5 May 2021
Ref 20355

SSD 8859
PROPOSED SUBDIVISION
1111-1141 ELIZABETH DRIVE, CECIL PARK
SITE ACCESS MATTERS

We refer to Transport for NSW's (TfNSW) letter to the Department of Planning, Industry & Environment (DPIE) dated 12 November 2020, as well as DPIE's letter to AE Design Partnership dated 23 November 2020, requesting additional information (RFI) in respect of the abovementioned development proposal.

DRAWING TITLE				
ROADWORKS PLAN				
PROJECT NO.	PLANSET NO.	RELEASE NO.	DRAWING NO.	REVISION
P1706121	PS03	R04	PS03-D100	D

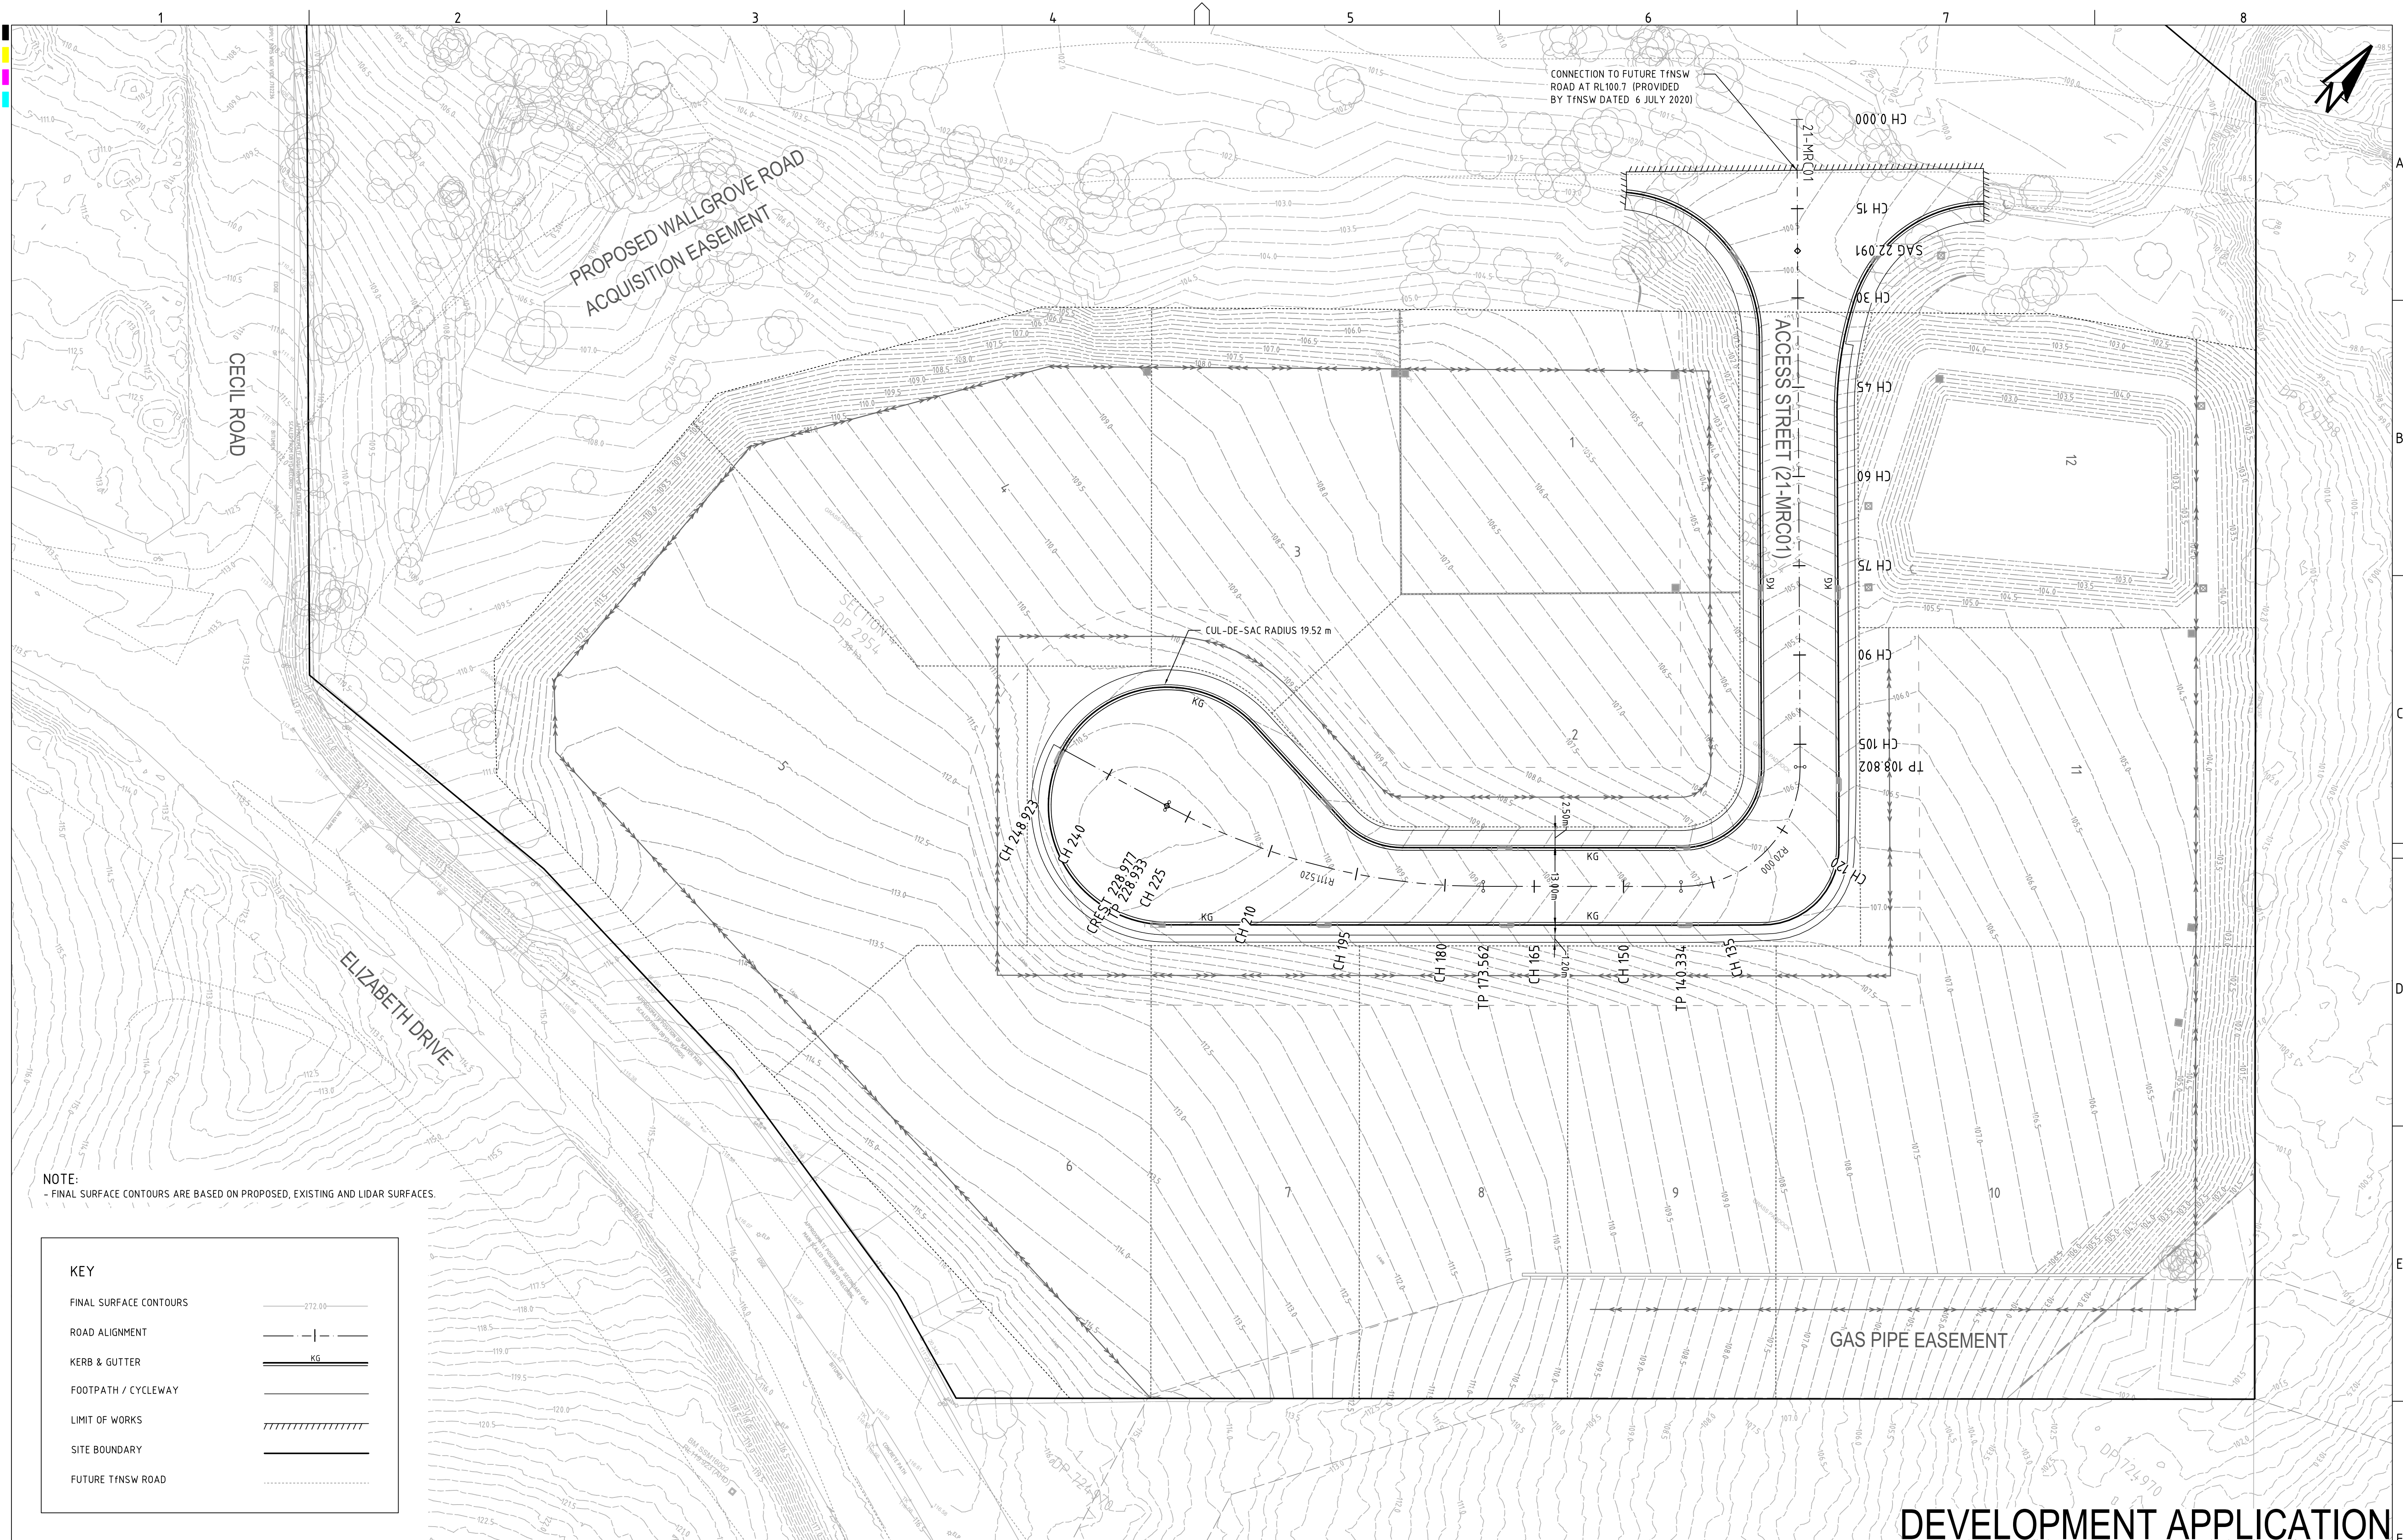
1. TfNSW has safety and operation concerns with the proposed location of the access in relation to the proposed new traffic signals and would not support it for the following reasons:
 - a. The proposed access to the site on the new realigned Wallgrove Road is located around a bend and TfNSW raises safety concerns with the sight distance at the proposed access road. A sight distance assessment should be provided to demonstrate the required sight distance is achieved.

- b. The traffic report p.11, shows a proposed left turn slip lane from the realigned Wallgrove Road onto the access road (access to the subject site), which also continues after the access road to form two lanes on the realigned Wallgrove Road continuing to the intersection with Elizabeth Drive. This will potentially cause significant safety and operational issues as traffic turning in and out onto and from the access road would assume these vehicles on the kerb side lane are turning left onto the access road, however, these vehicles may choose to continue to travel straight on Wallgrove Road. Further, visibility and sightlines for traffic exiting from the access road would also be restricted by traffic travelling along the kerb side lane before the proposed access road.

- c. The proposed access to the site is uncontrolled and the potential for conflict is high due to it being at a point where drivers are merging and diverging.

2. TfNSW require the proposed access to the site on the realigned Wallgrove Road to be located to the farthest point of northern boundary of the site, away from the proposed intersection at Cecil Road.

TfNSW have advised that the future signposted speed limit will be 60km/h along this section of the realigned Wallgrove Road, whilst the design speed limit should be 70km/h. Accordingly, based on Table 3.2 of Austroads *Guide to Road Design Part 4A: Unsignalised and Signalised Intersections*, the SISD for a 70km/h road with a *reaction time* of 2.0 seconds is 151m, as set out below.

I understand the road design of the future Wallgrove Road realignment is still a work-in-progress, nevertheless a sight distance assessment is provided later in this report, indicating that the 151m safe intersection sight distance (SISD) requirement is and can be achieved.

It should be noted that the previous intersection design proposed and included within the Traffic Report submitted with the application (dated 14 August 2020) has been revised, with the design now including a dedicated left-turn slip lane as part of the “half seagull” design.

As noted in the foregoing, vehicular access to the site is proposed to be provided in the form of a “half seagull” intersection located off the realigned Wallgrove Road, set back approximately 80m south-west of the north-eastern site boundary and approximately 110m north-east of the future Wallgrove Road & Cecil Road signals.

Generally speaking, intersections should be located as far back from traffic signals as possible, however in this instance, the curvature of the realigned Wallgrove Road to the north of the site presents some potential sight distance issues.

Relocating the proposed new access further to the north may result in a corresponding reduction in sight distance. It is therefore a balancing act between providing a suitable offset to the new Cecil Road signals and providing sufficient sight distance.

With respect to *MU Group's* concern regarding the angle of exiting vehicles, this is simply rectified by the inclusion of linemarking, as illustrated in the screenshot image of the concept plan below. The extent of linemarking illustrated in the concept plan is based on the swept turn path requirements of an 8.8m long MRV truck, noting that the intersection has been designed to accommodate B-Triples. Larger trucks will therefore traverse over the linemarking which is also commonplace and acceptable in today's urban environment.

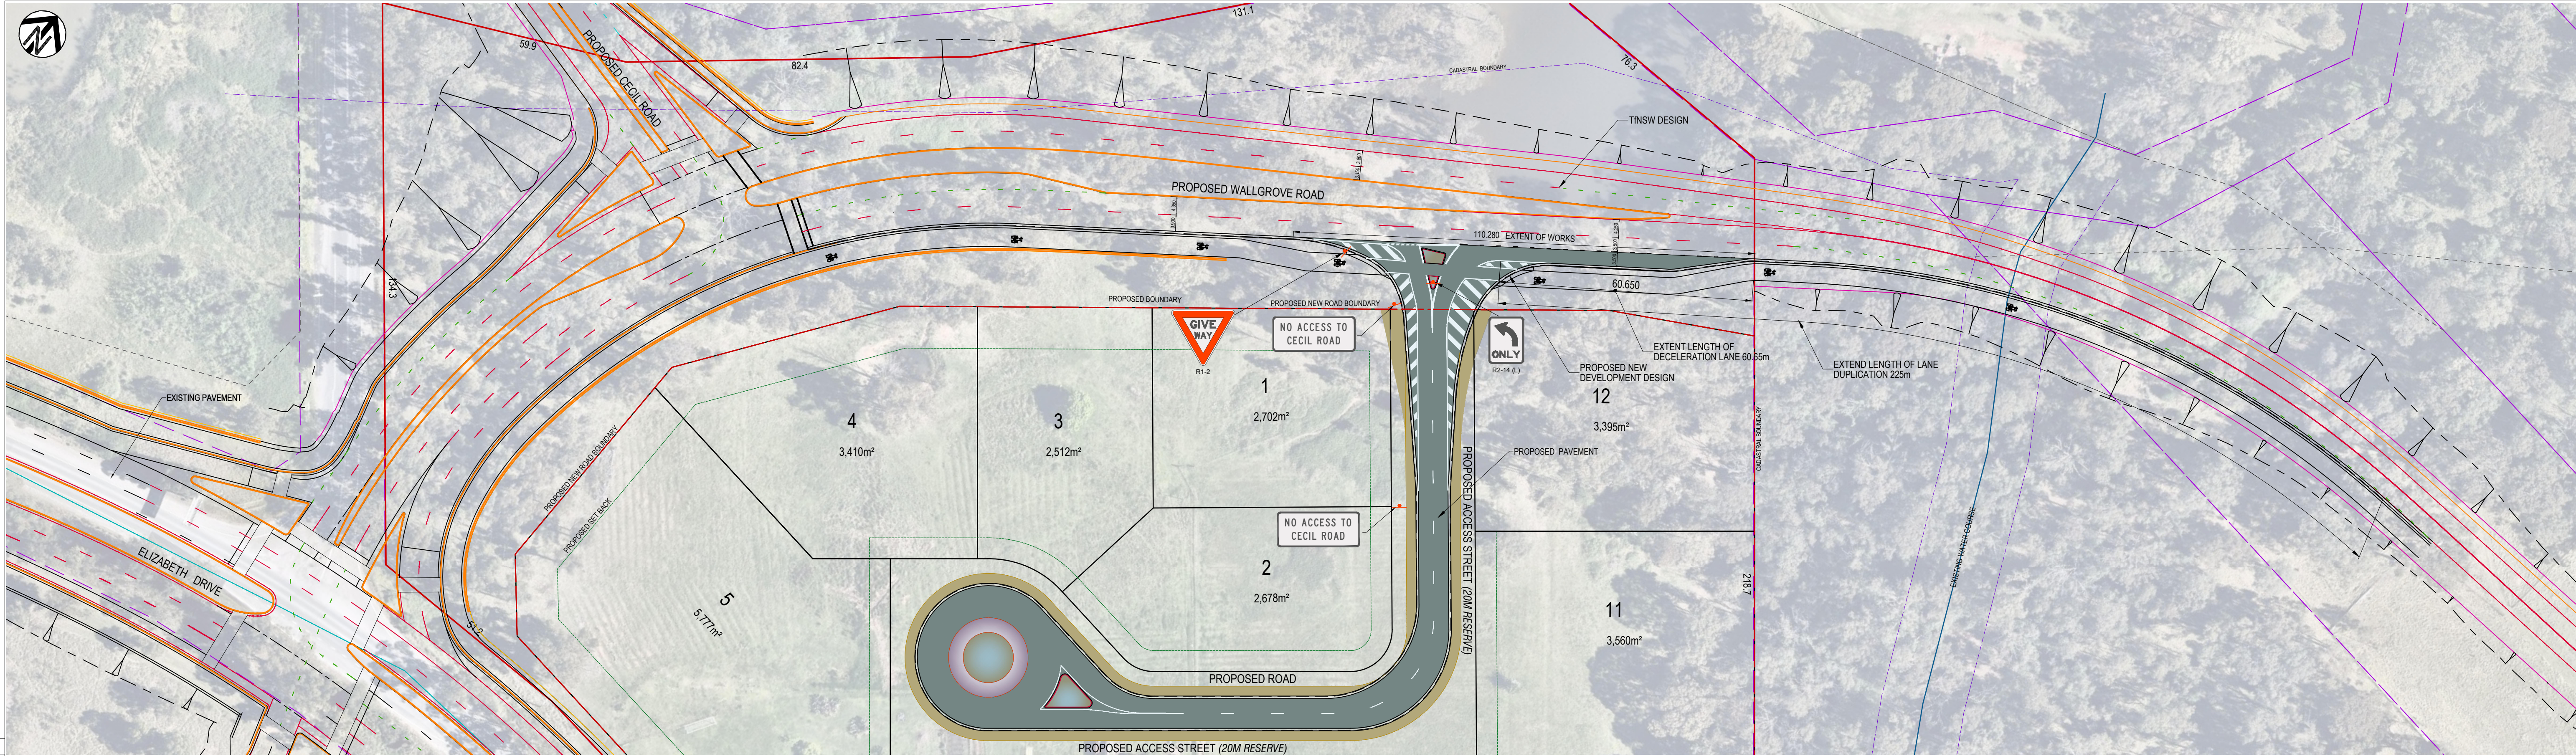
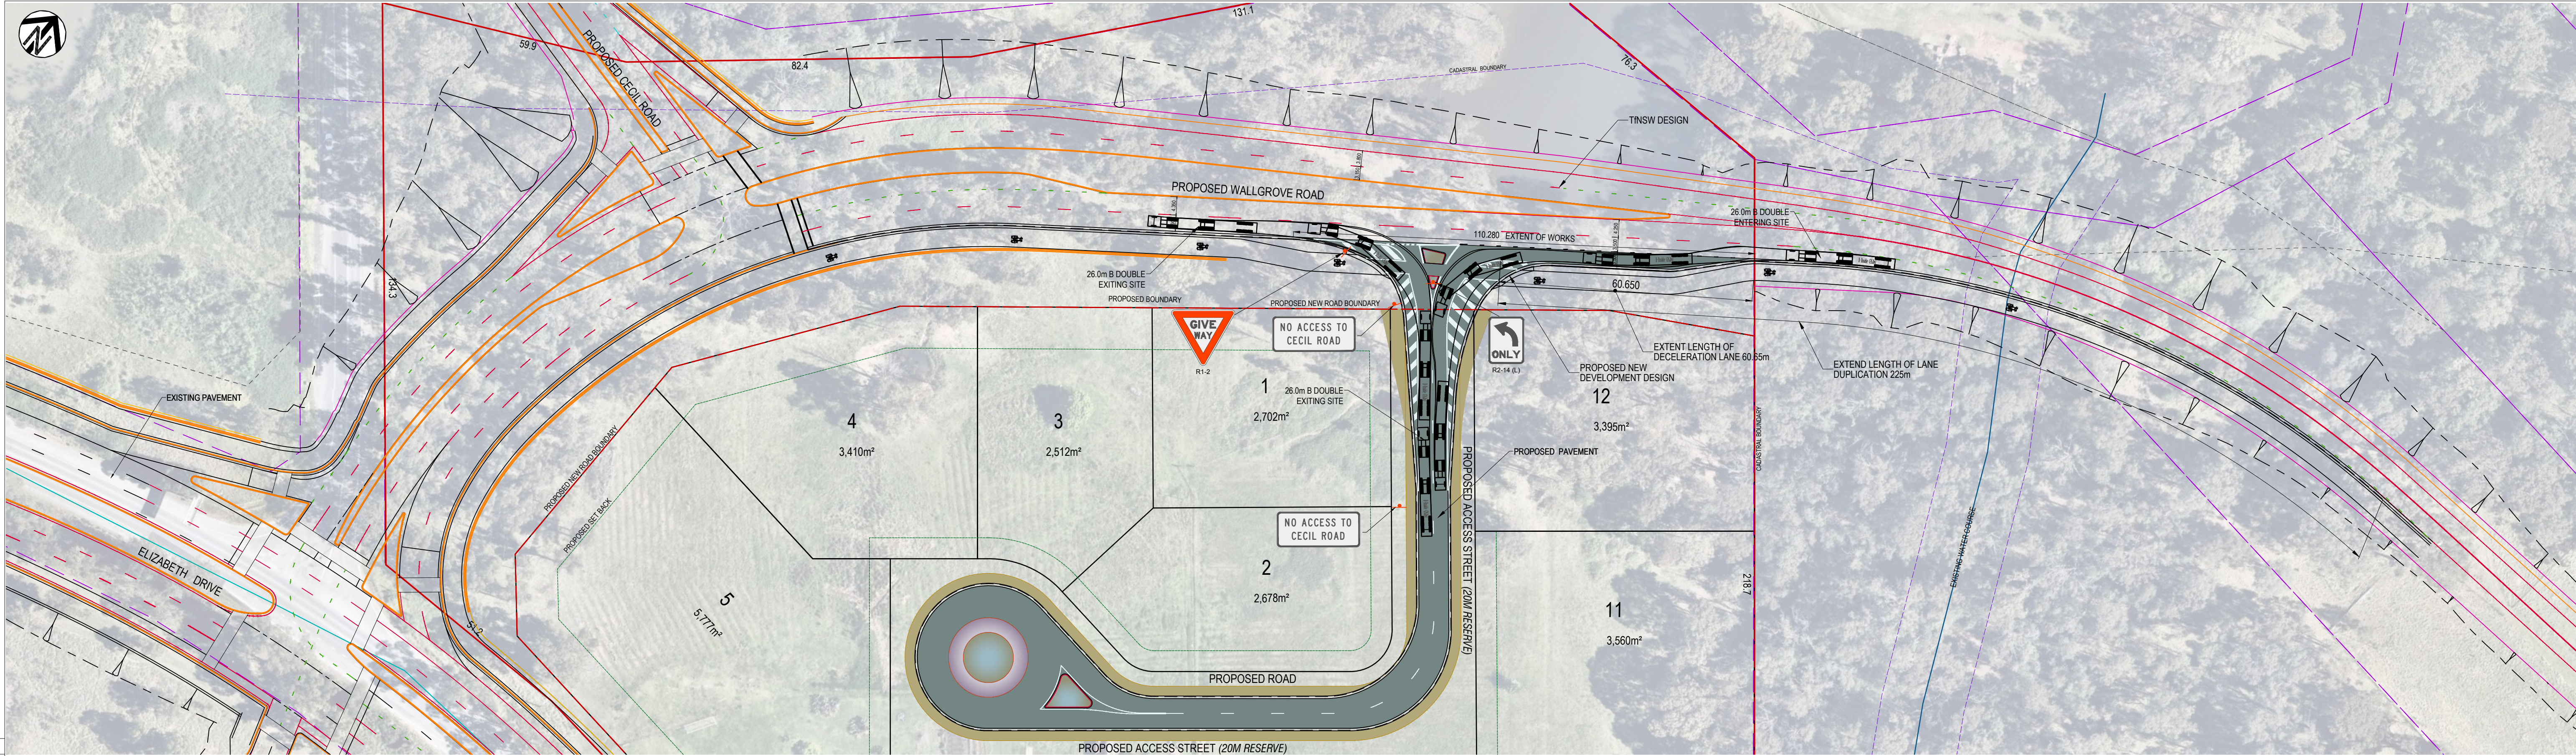
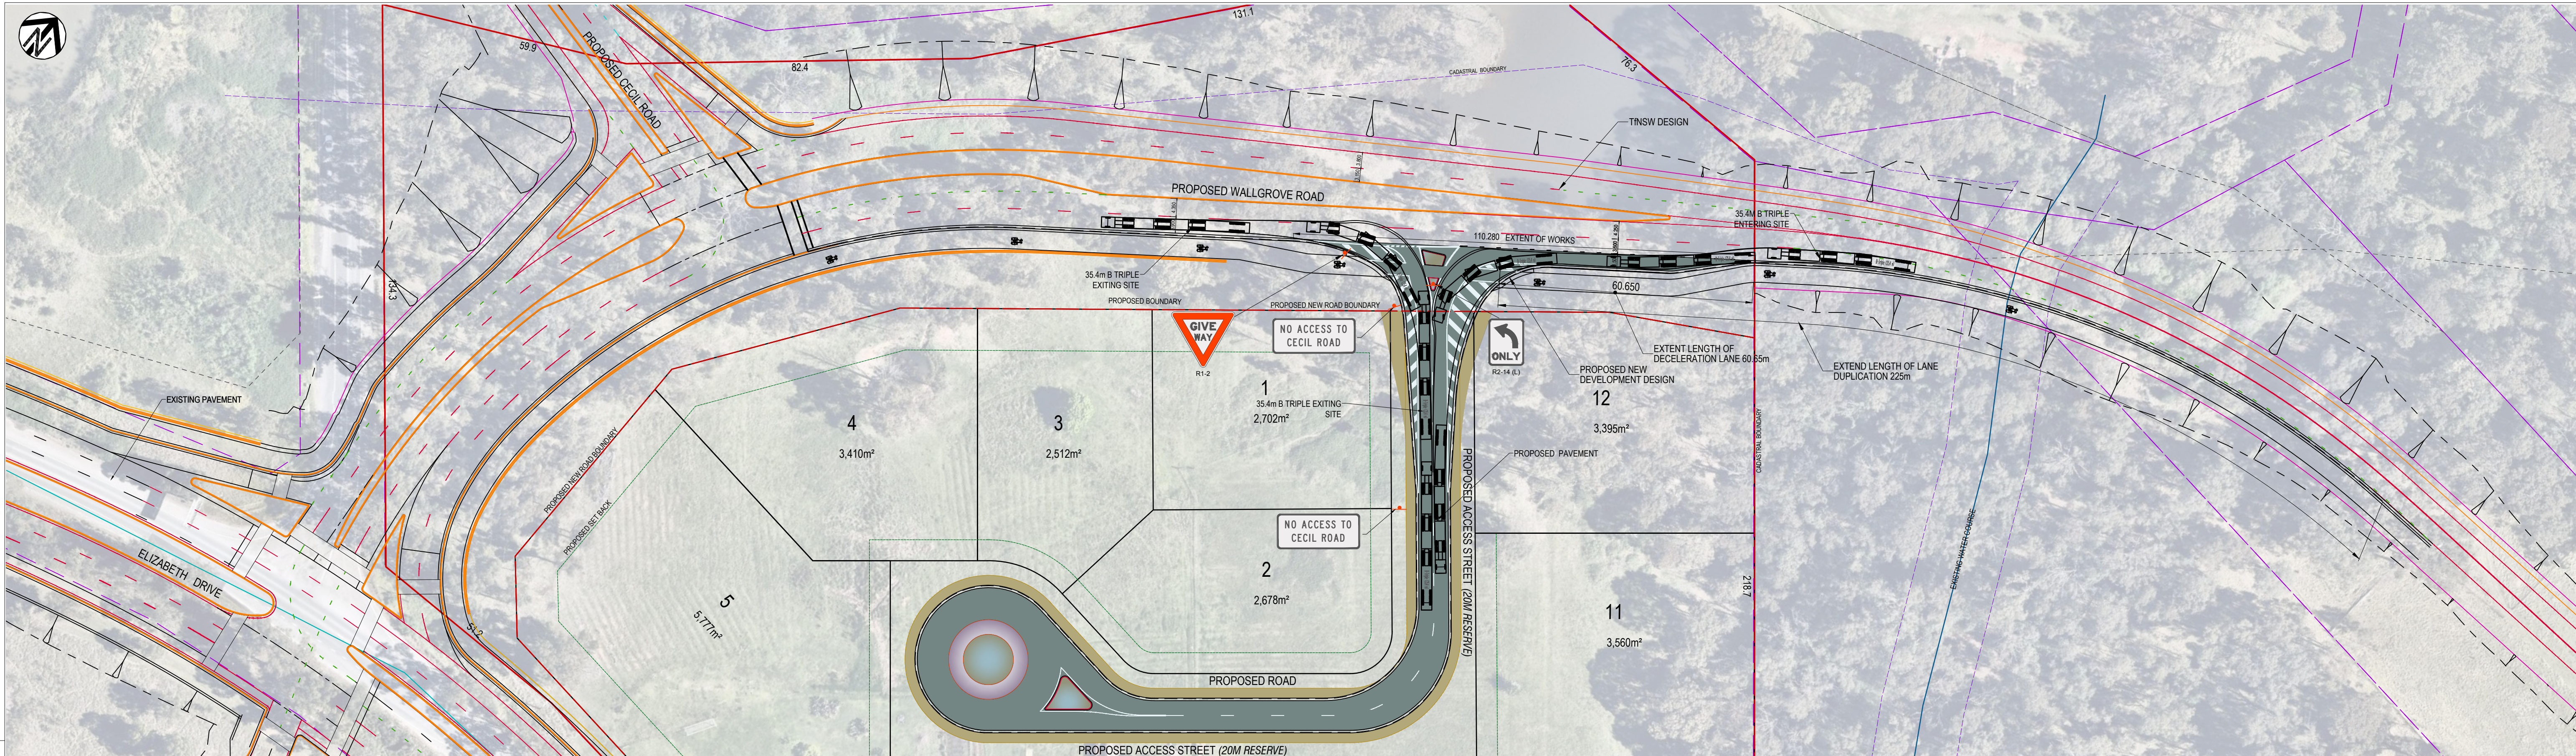
5. A swept path analysis for the largest vehicle accessing the site should be provided.
